**Planning Application Reference No.:** 3/2022/0317

**Address of Development:** Land at Higher Standen Farm and Part Littlemoor Farm Clitheroe

**Address of Development:** Standen Hall Farm (Residential phases 5 & 6 Reserved Matters)

**From:** [REDACTED]  
**Sent:** Thursday, June 05, 2025 10:40  
**To:** 'Planning' <planning@ribblevalley.gov.uk>  
**Subject:** Matters of concern wishing to be noted for application 3/2022/0317 - re. Reserved Matters application in respect of Phase 5 and 6

Storey Heights Plan Phase 6

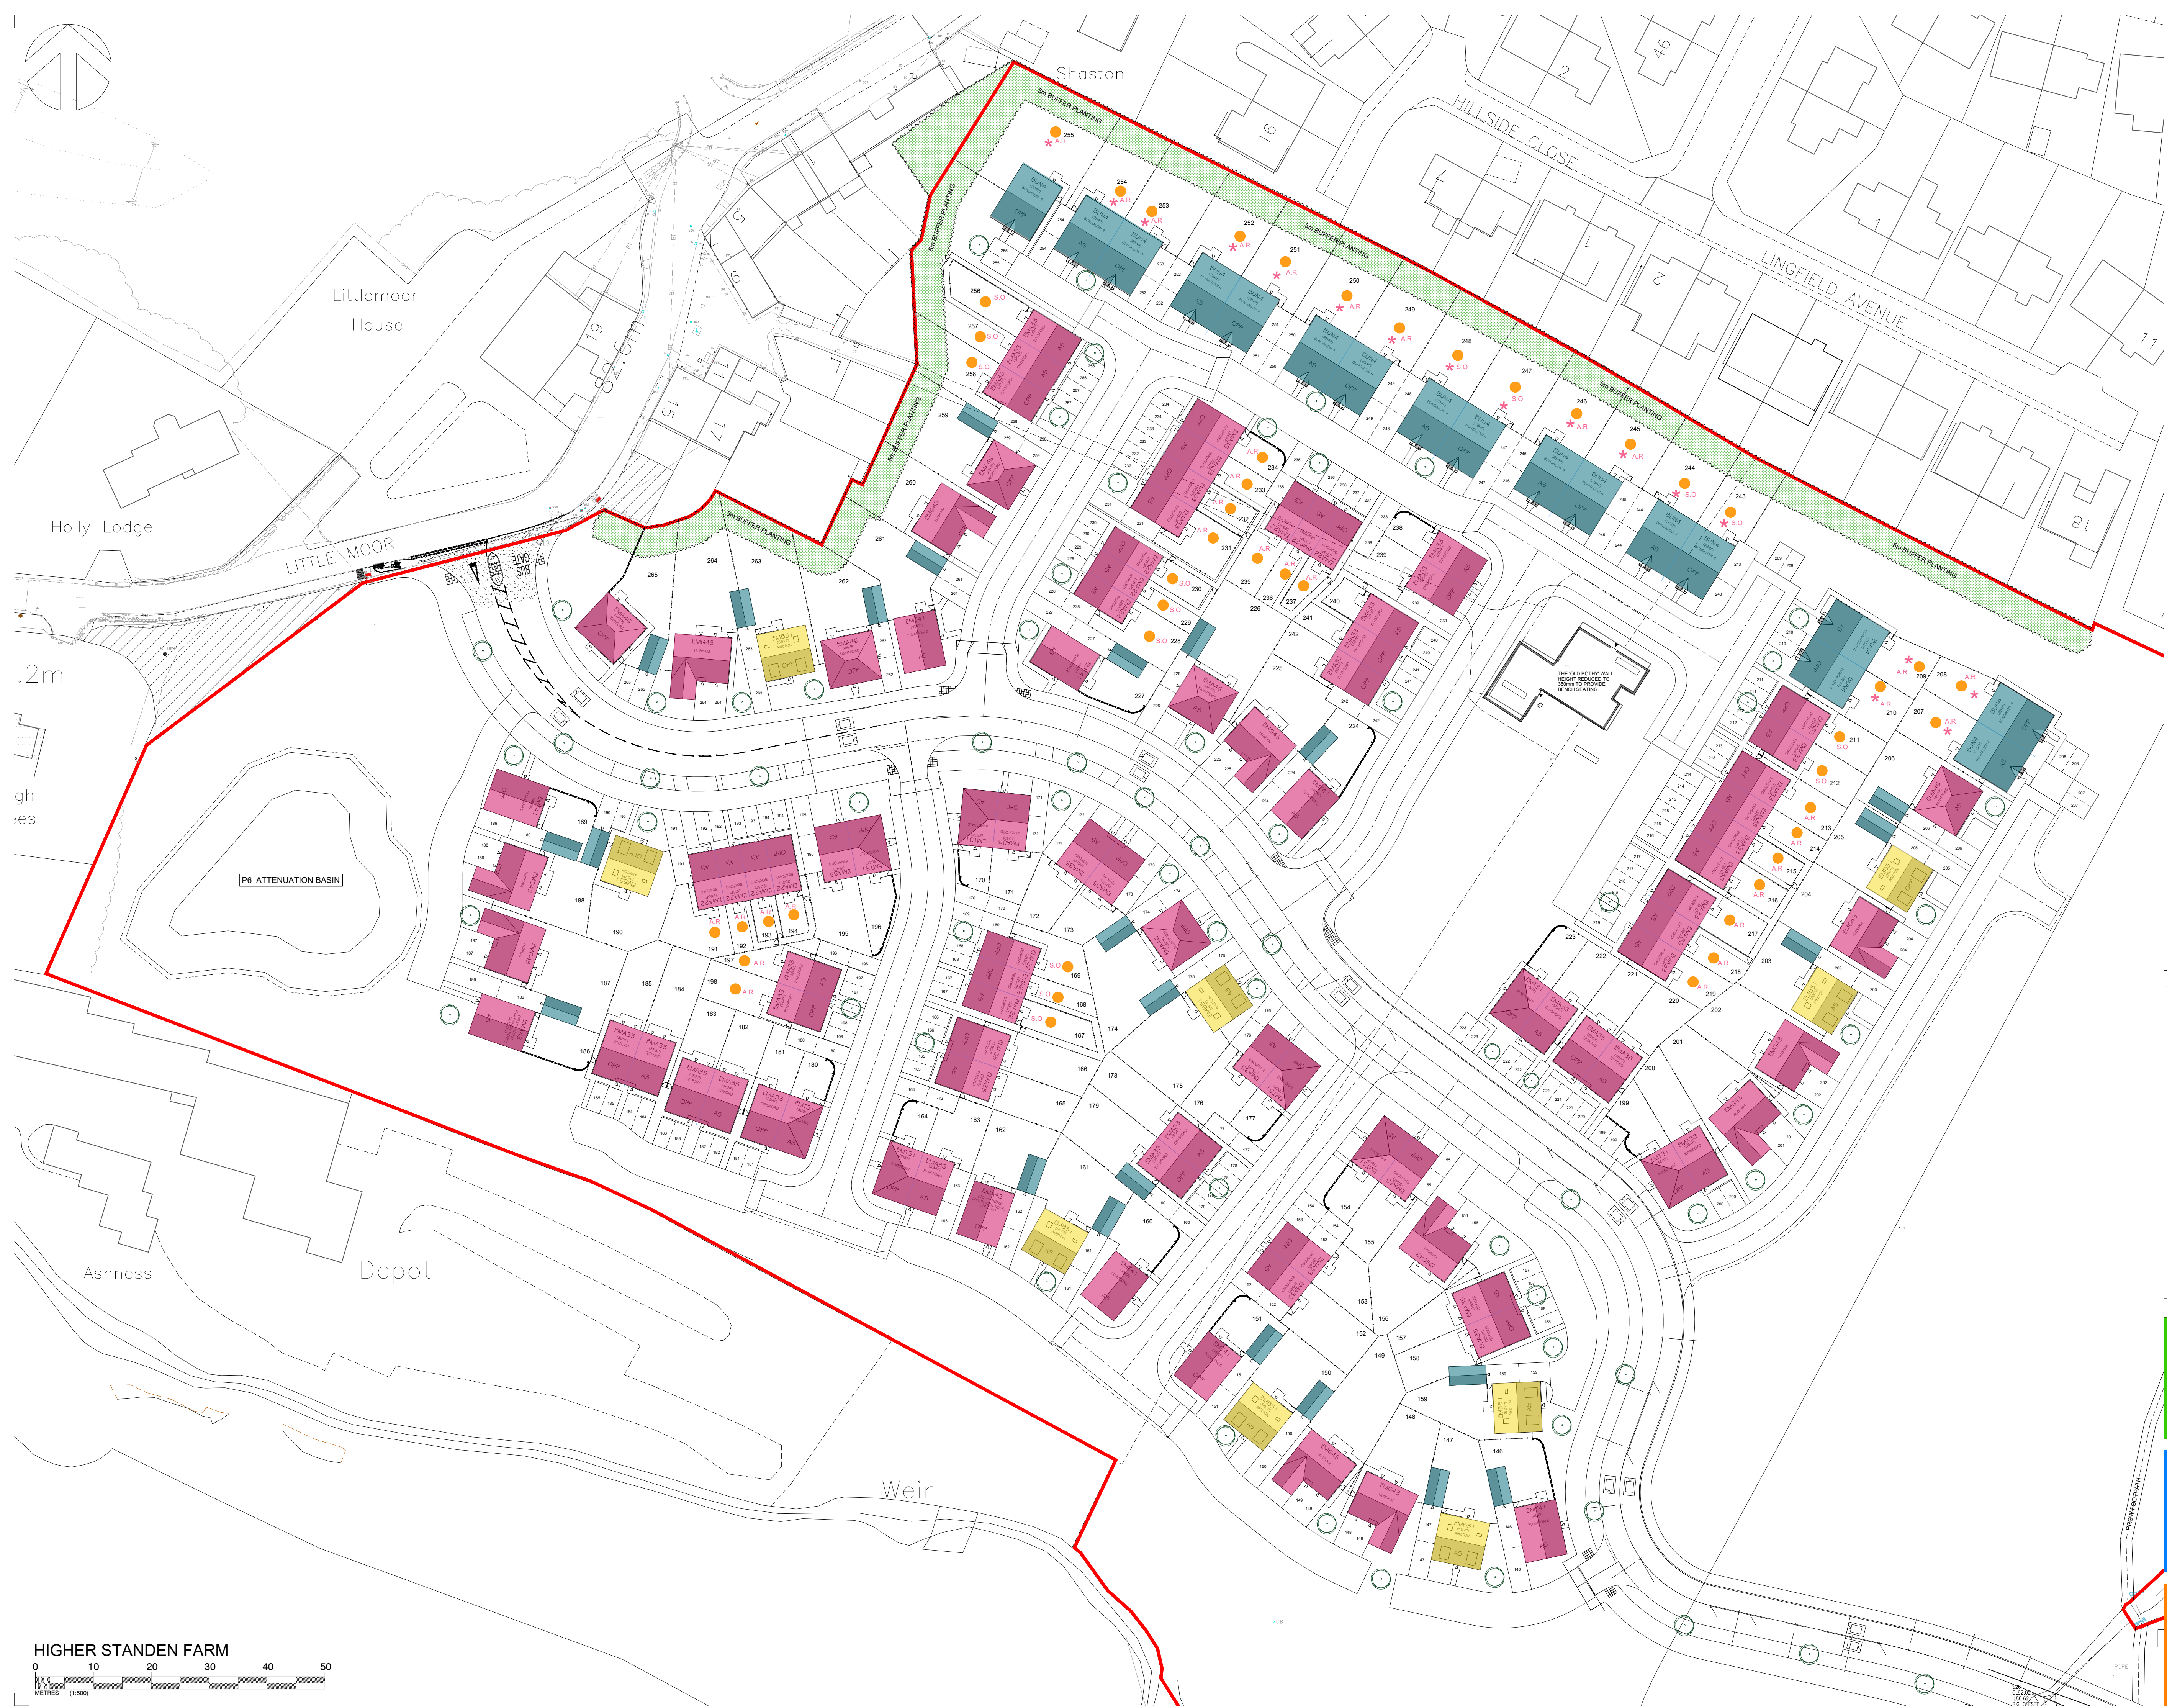
2. Unlike the border of the proposed development with Hillside Close and Lingerfield Avenue properties, we will have **seven** properties surrounding [REDACTED] whereas most properties along their row have only two properties at most impacting them. And unlike [REDACTED], all their properties are bungalows, whereas [REDACTED] the **seven** properties are at least 2 storey houses, with one being a 2.5 storey house (plot 263).

The rising elevation of the field means that some of these properties will 'tower' over us, creating a natural 'amphitheatre' resulting in both loss of privacy and enhanced noise issues coming from their gardens. To mitigate this please could consideration be given to replacing plots 259, 260, 262 & 263 with bungalows and so reducing the 'wall height' of some of these **seven** semi-circular positioned properties.

Maze Layout [1:200]

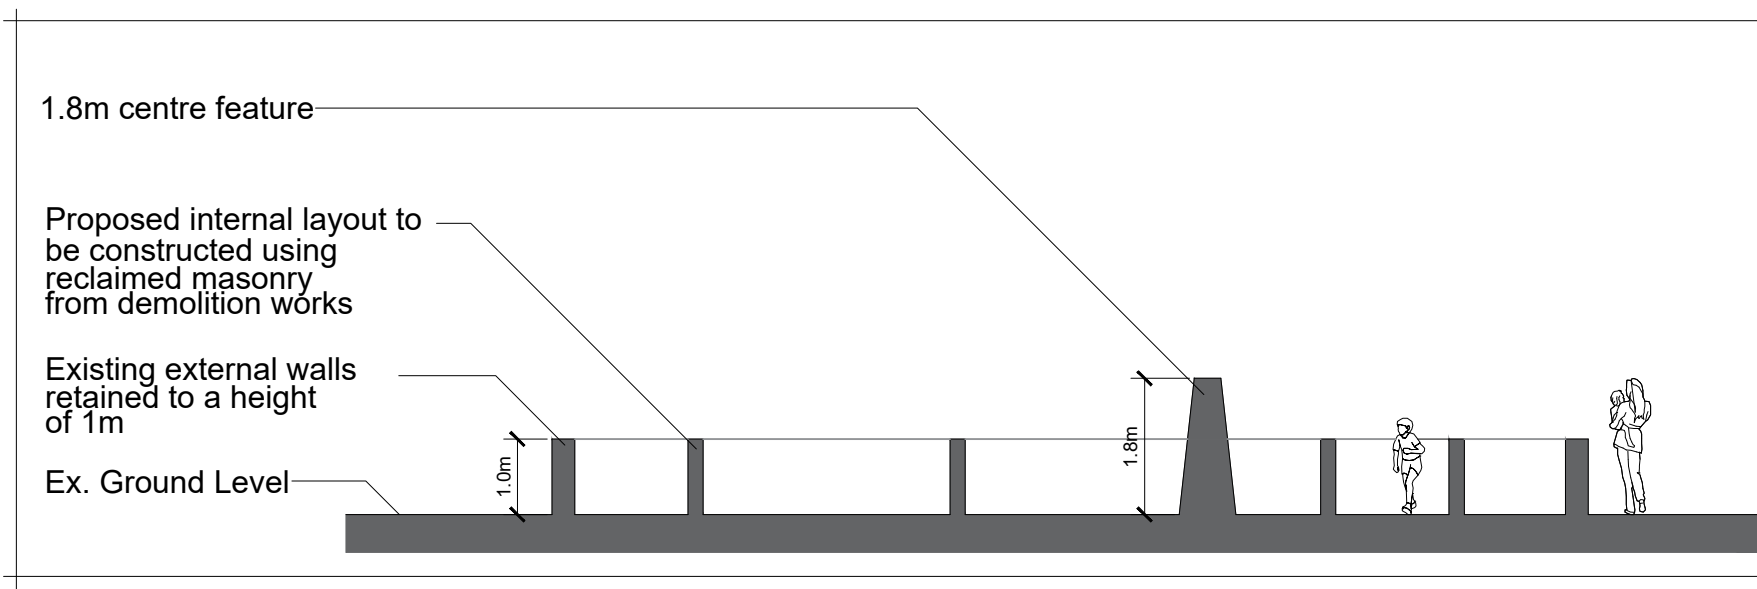
of the area. I oppose the removal of the Bothy as this is an integral part of what Littlemoor once was and where the farm once stood. Why is this allowed to be reduced to a maze surely this should be restored to its former glory as it must be listed as all of Littlemoor is. It makes a mockery of why Littlemoor is listed if you can simply remove parts just because of the expense of making them back to what they were. the whole development is too imposing and will dramatically change the tranquility history of the area
